17 July 2019

Our Ref: R/2019/2/A
File No: 2019/351568

SSD 9835 - Sydney Football Stadium (Stage 2 Design, Construction and Operation), 40-44 Driver Avenue, Moore Park

1 BENCH TYPE 1 | PRECAST CONCRETE WITH TIMBER INLAY
1:50
PLAN

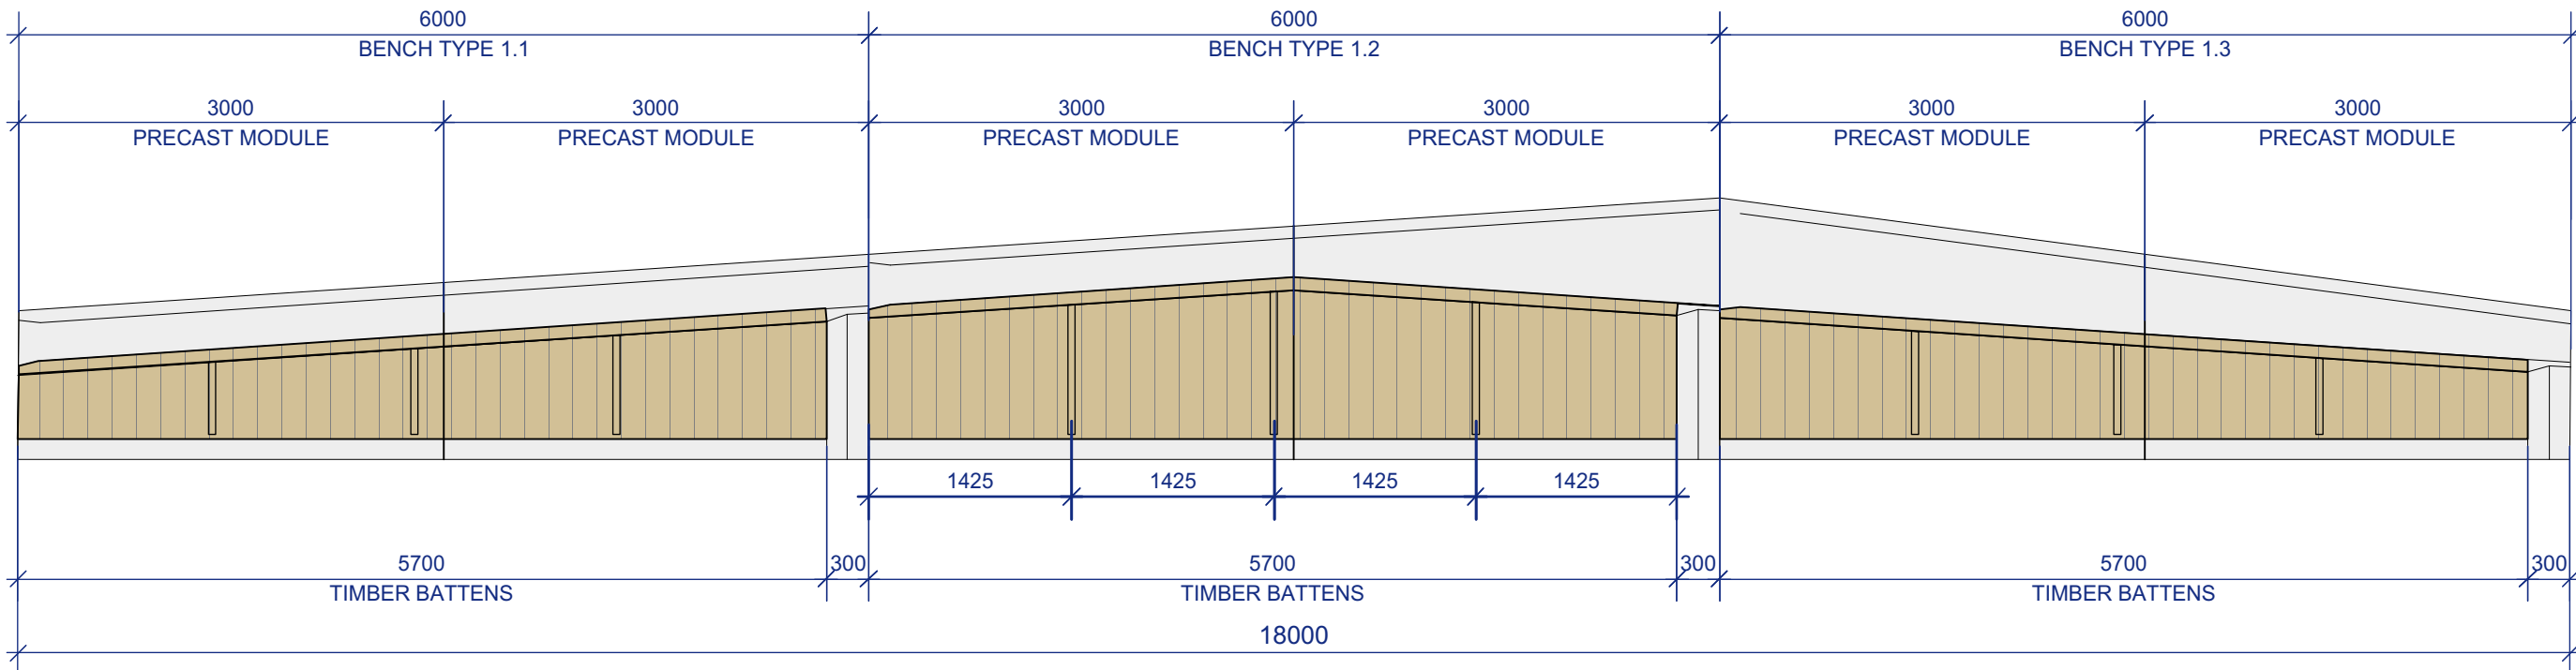
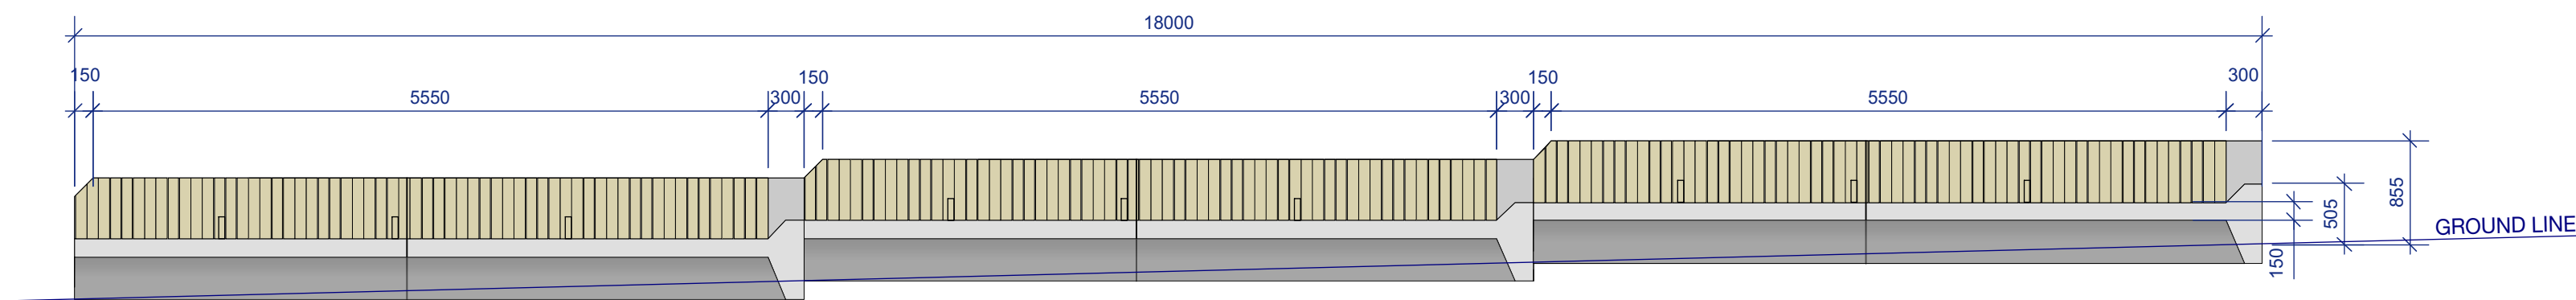
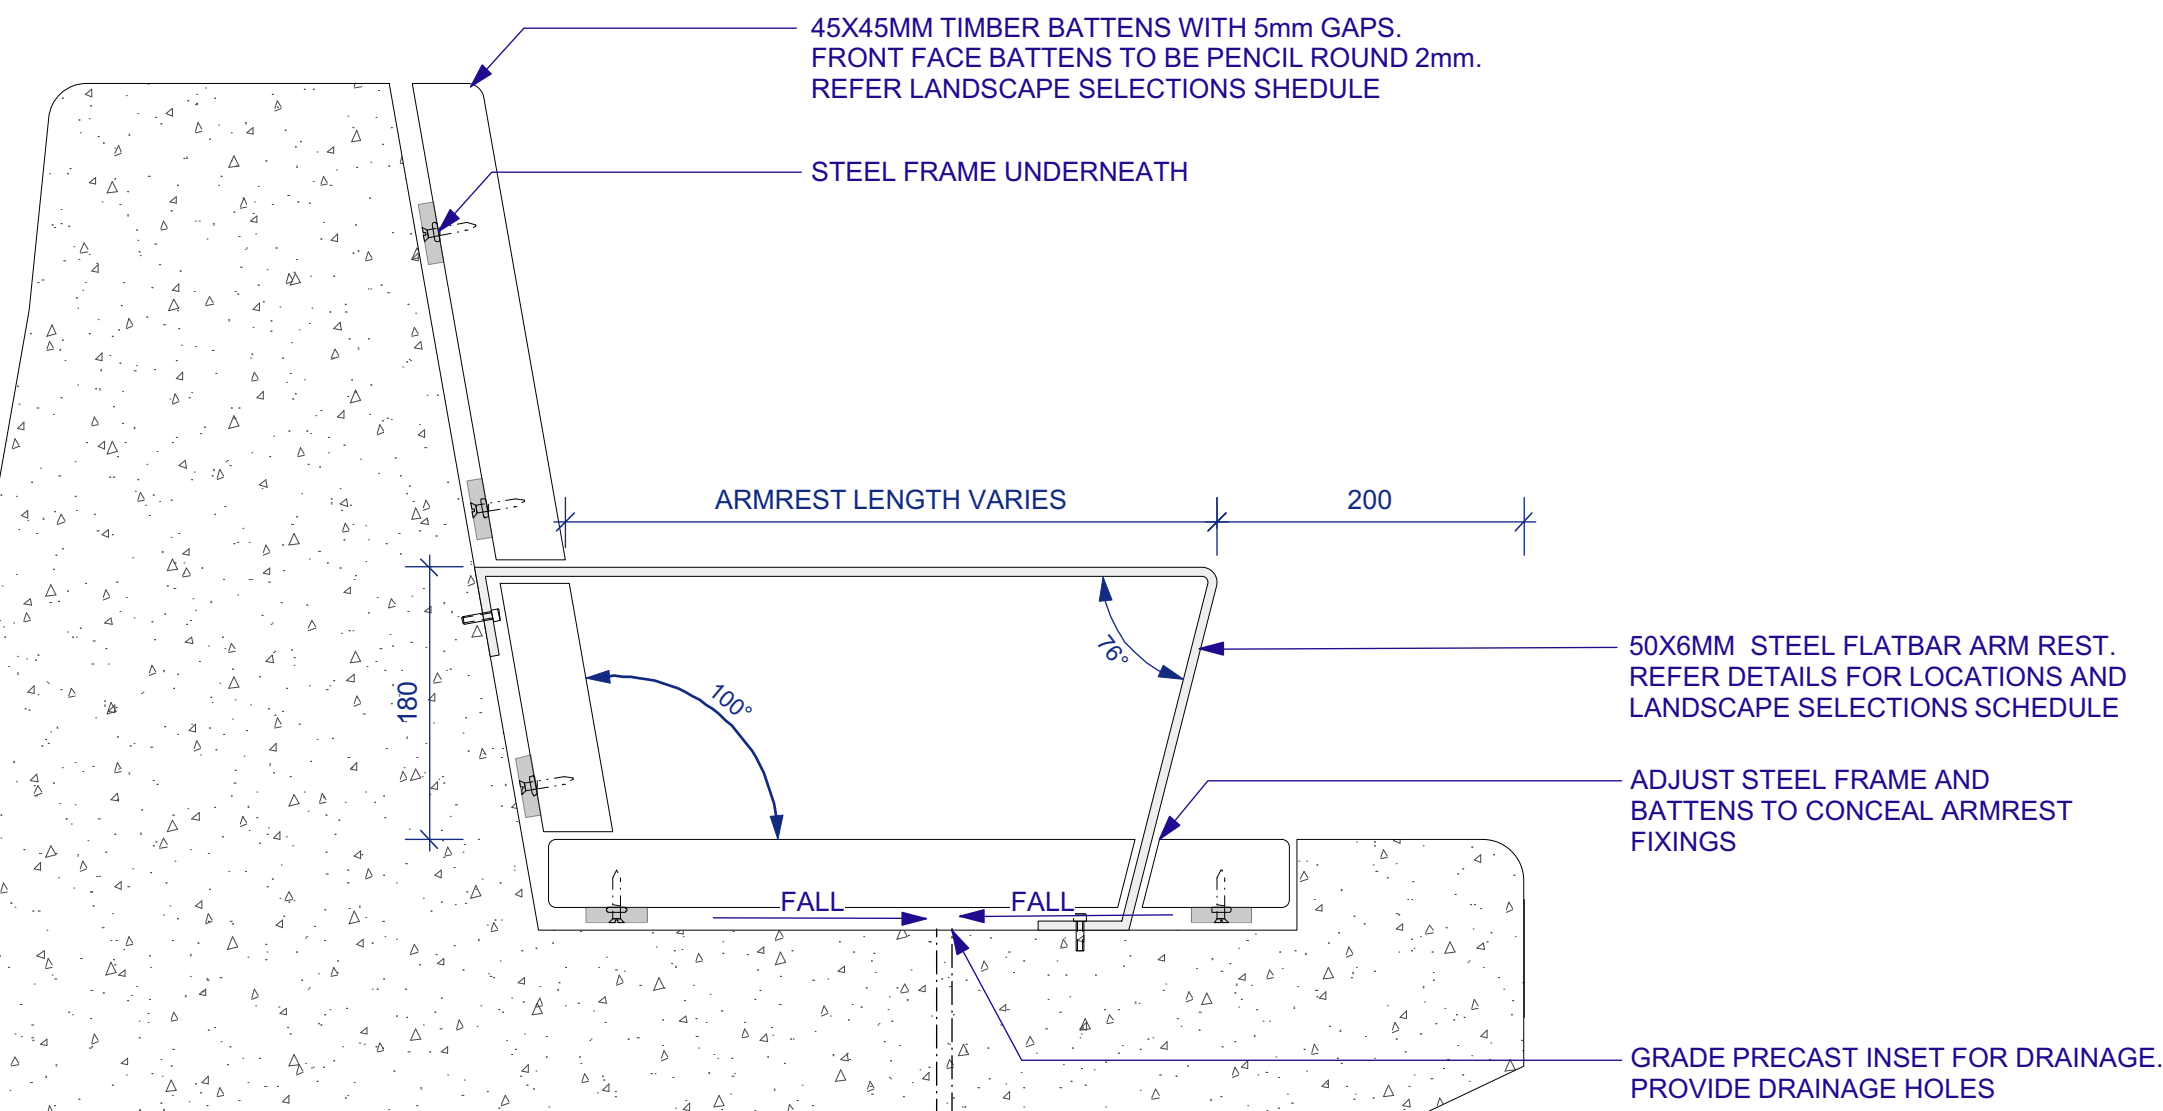
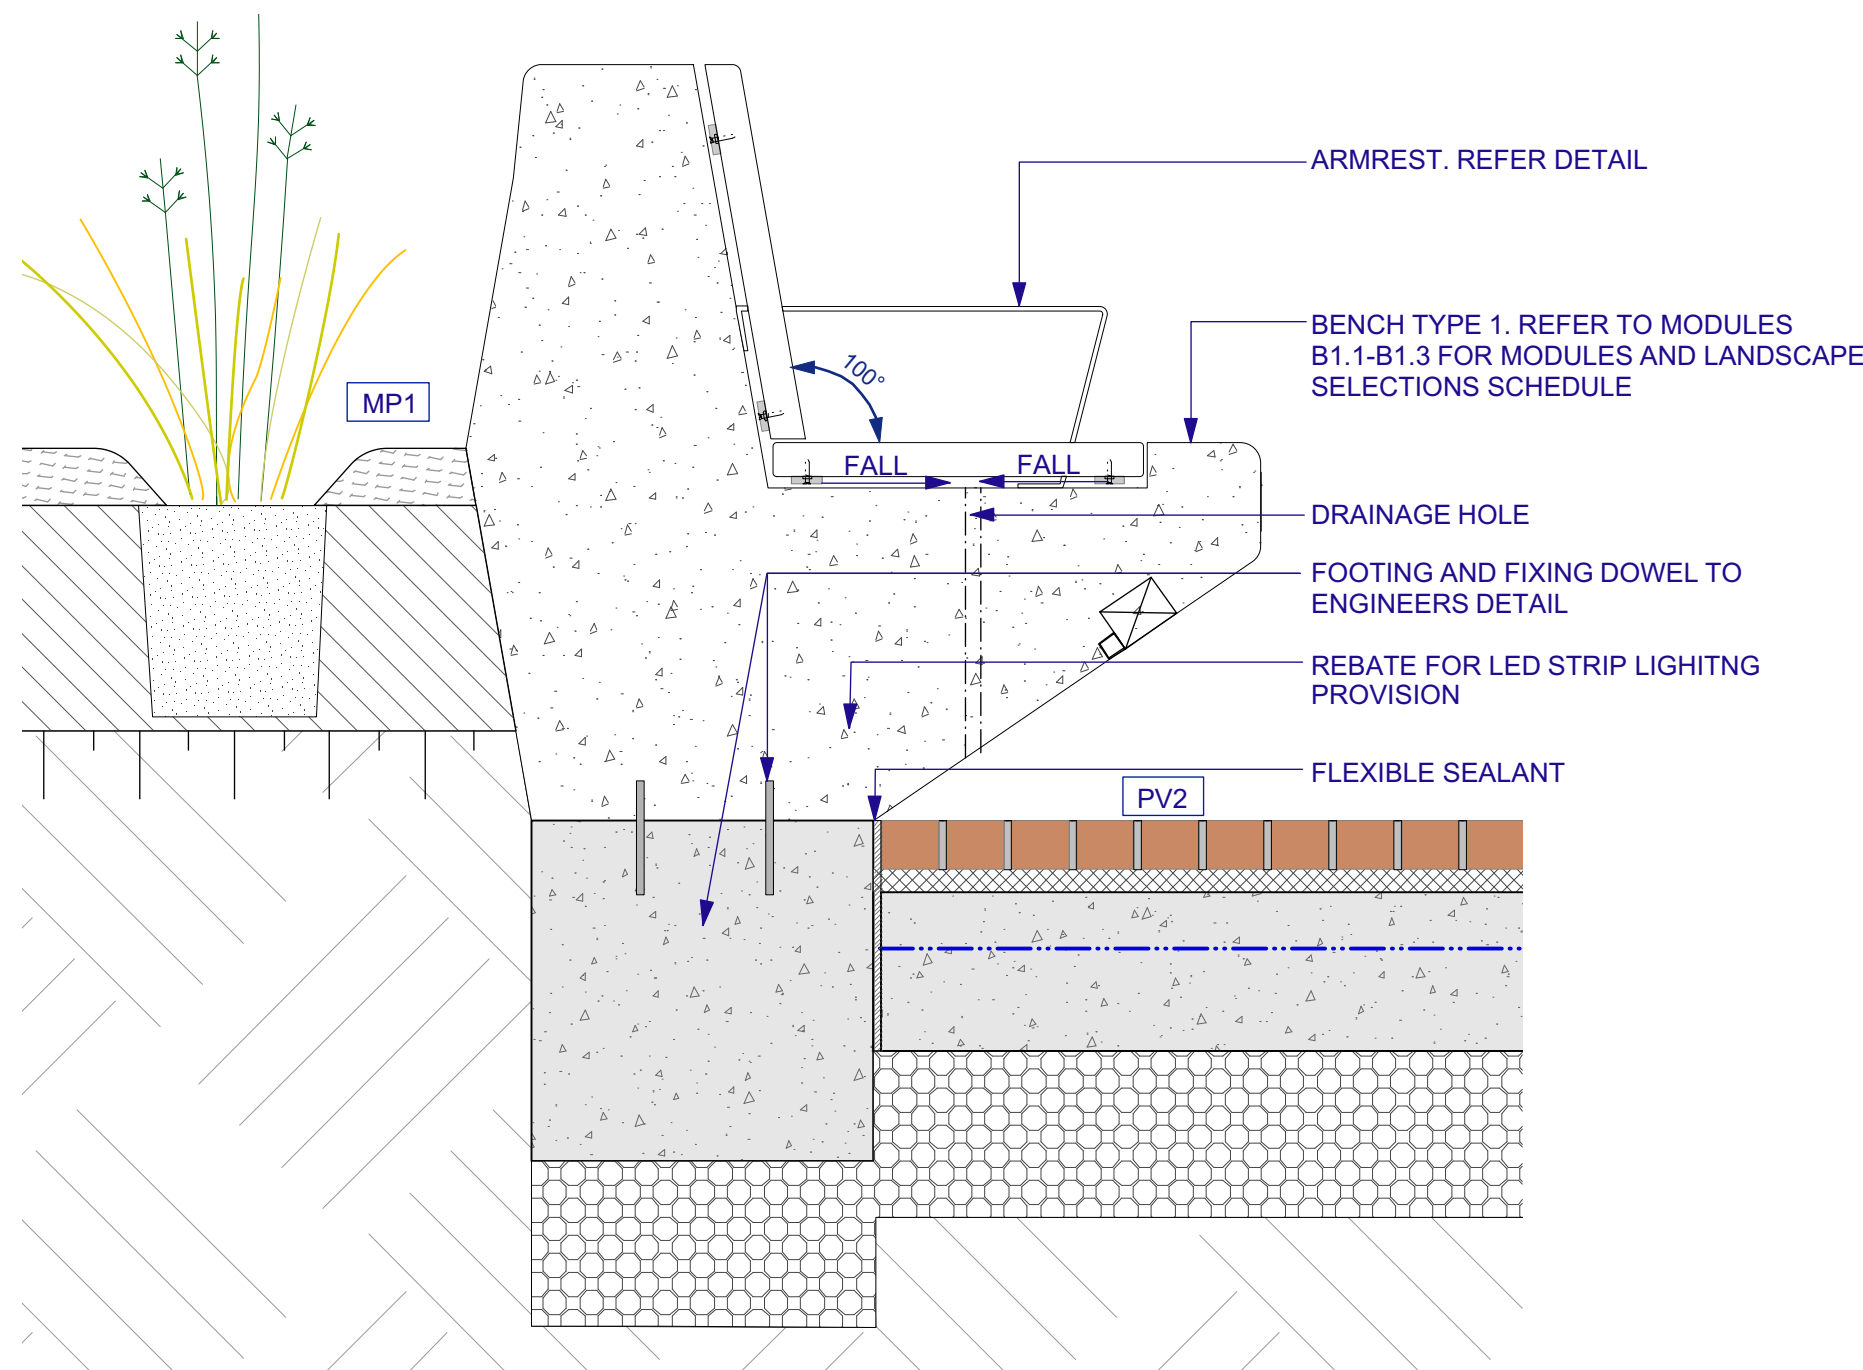
The proposal also provides integrated seating options in the public domain. To ascertain that people with disabilities can enjoy seating with equity that is safe, predictable and consistent, the seating should be designed in accordance with the performance standards outlined in *Part 1.4 – Stairs and ramps* of the Draft Guidelines in the following ways:

- Ensure that some integrated seating include back and arm rests to make seating more inclusive for the elderly;
- Provide regularly recessed areas in integrated seating to enable wheelchair users and families with prams to sit together;

4 FURNITURE ELEMENT TYPE 1 | BICYCLE HOOP
1:10 PLAN F1

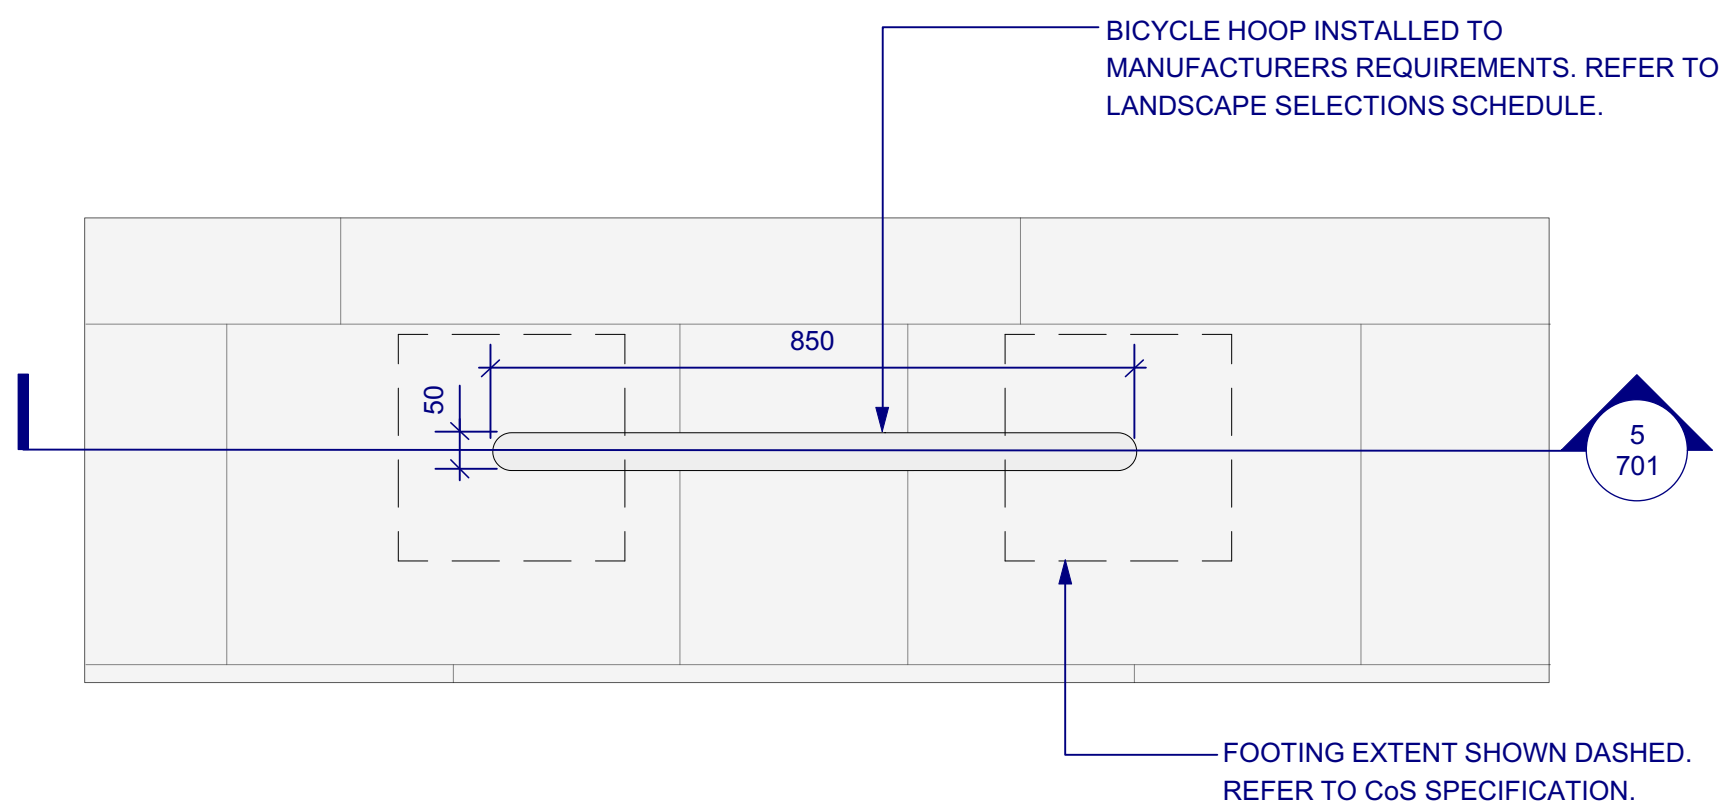
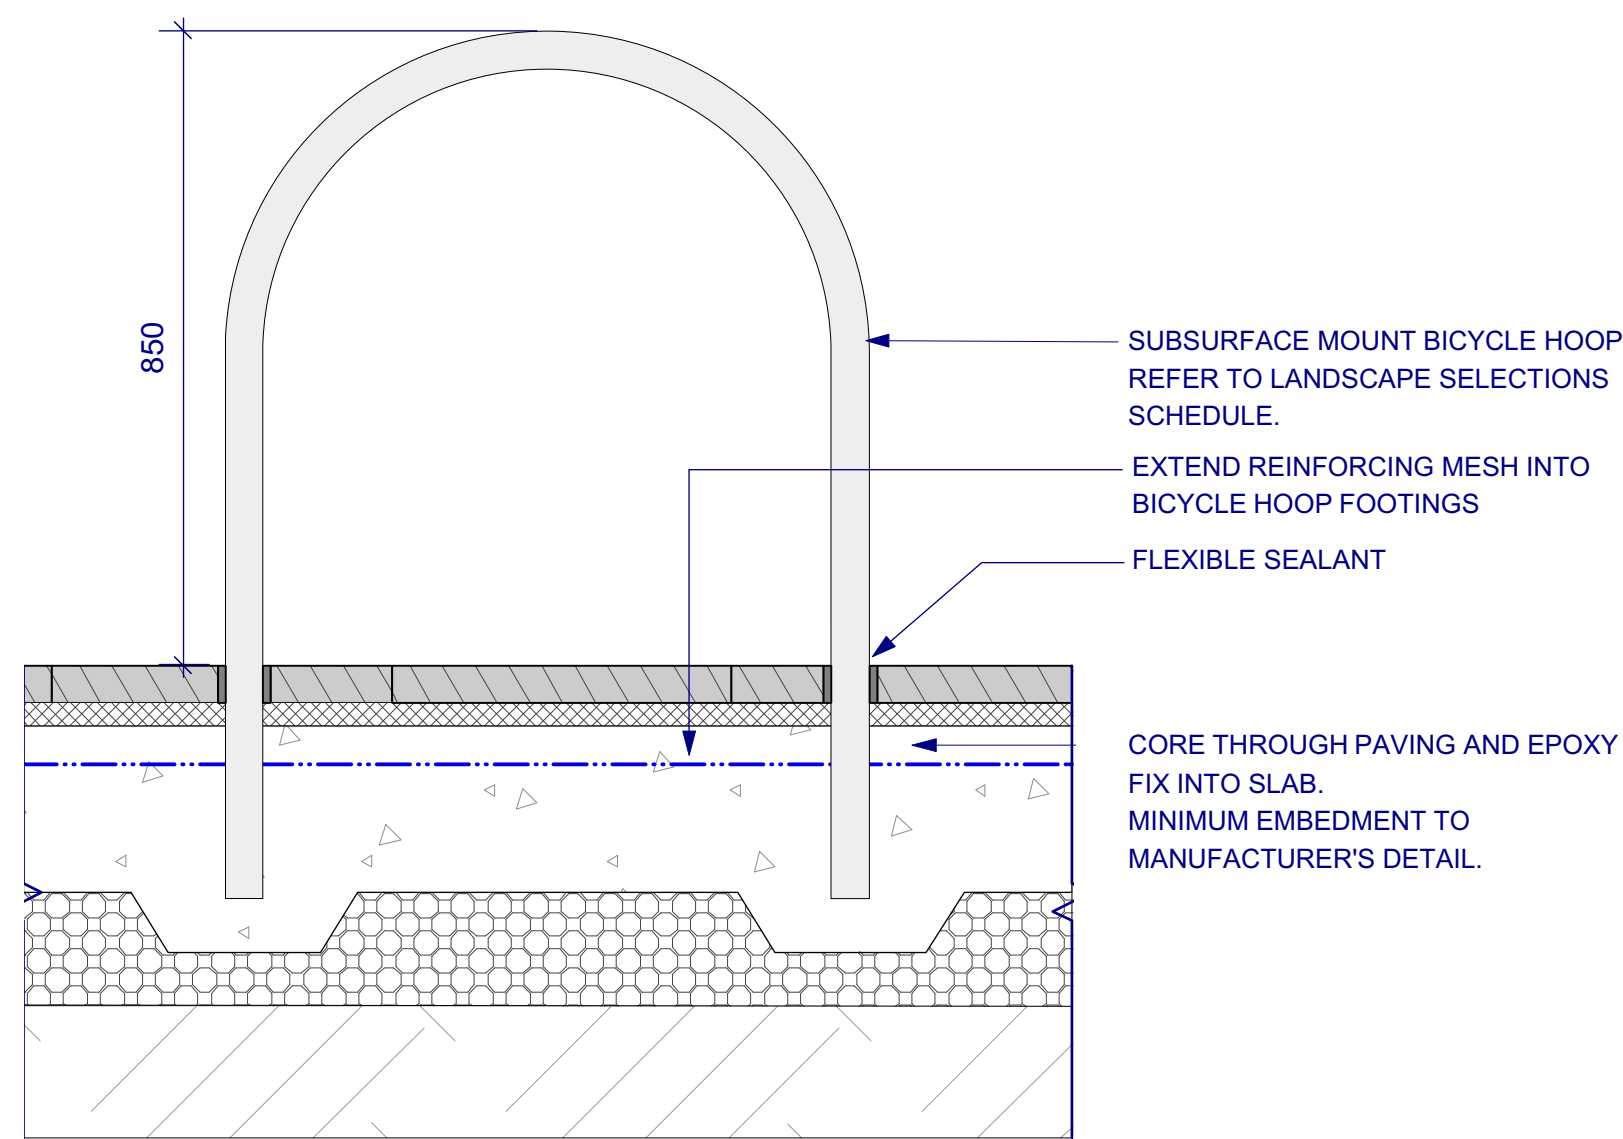
Moreover, the bicycle plan as illustrated in the landscape and public domain plans, demonstrates that the bicycle racks within the public domain are not weather protected and are not secured. These racks are ideal for visitors and spectator use. However, this does not comply with the staff/employee bicycle parking requirements of Sydney DCP 2012. Additionally, no lockers, showers and bathrooms have not been provided as part of the end of journey facilities of the stadium.
